Recommendation: Approve

Applicant: Hayfield Homes Construction Limited

Proposal: Changes proposed to the landscaping details, to replace the timber knee rail around the area of 'EM2 Standard General-Purpose Meadow Mixture' with a 1.0m high stock-proof timber post and rail fence, along the eastern edge of the development (proposed as non-material amendment to 22/00959/REM)

**BERRY HILL ROAD, ADDERBURY - BOUNDARY TREATMENTS PLAN**

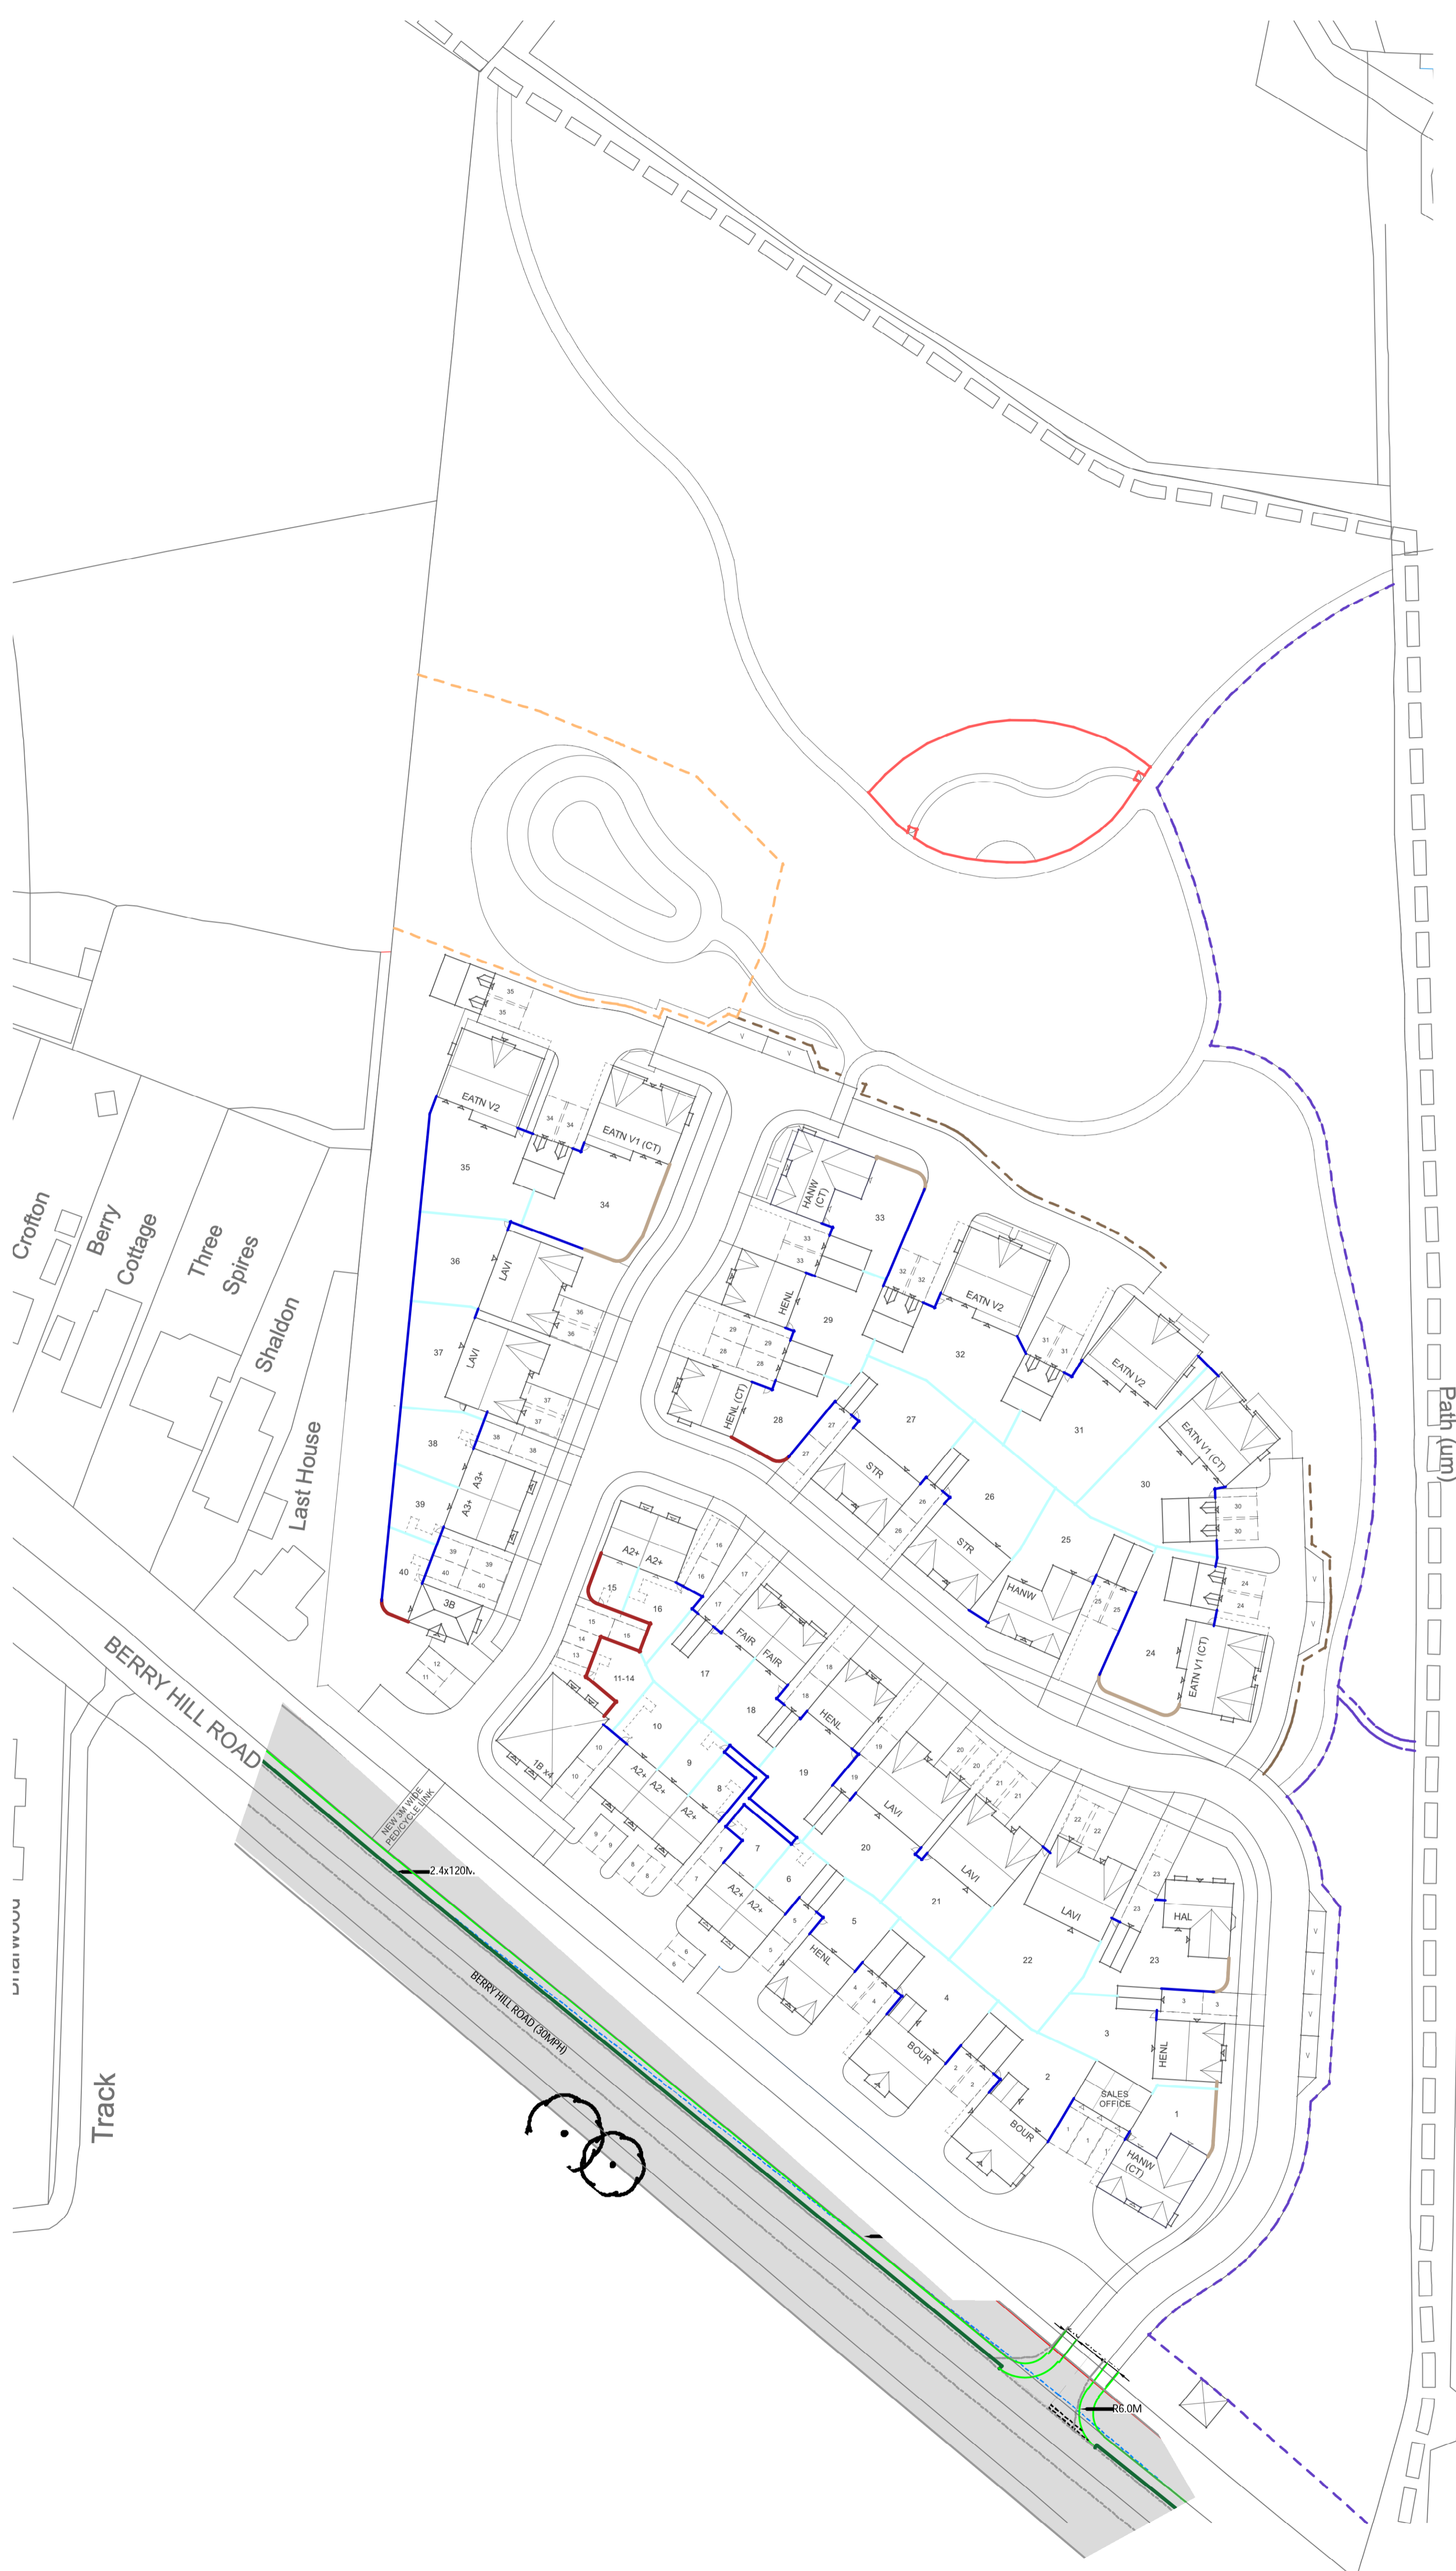
- 2.1 The proposed change relates to the landscaping details, specifically to replace the timber knee rail around the area of 'EM2 Standard General-Purpose Meadow Mixture' with a 1.0m high stock-proof timber post and rail fence, along the eastern edge of the development (proposed as non-material amendment to 22/00959/REM).
- 2.2 This was originally approved under 22/03437/DISC and later amended to consider a biodiversity enhancement under 23/01777/DISC. This application looks to amend the drawing numbers relevant to the approved Boundary Treatments plan and Enclosure details drawing.

5.4 The scheme already benefits from an approved timber knee rail around the revised areas of EM2 General Purpose Meadow Mixture across the site. This nonmaterial amendment sees the knee rail replaced with a 1m high stock proof timber post and rail fence.

5.6 The new fencing would complement the existing approved scheme and assist in continuing to protect the biodiversity enhancements across the site. The change would not raise any new issues and does not contradict previous agreements or amendments. All the proposed changes are within the site as defined by the site edged red.
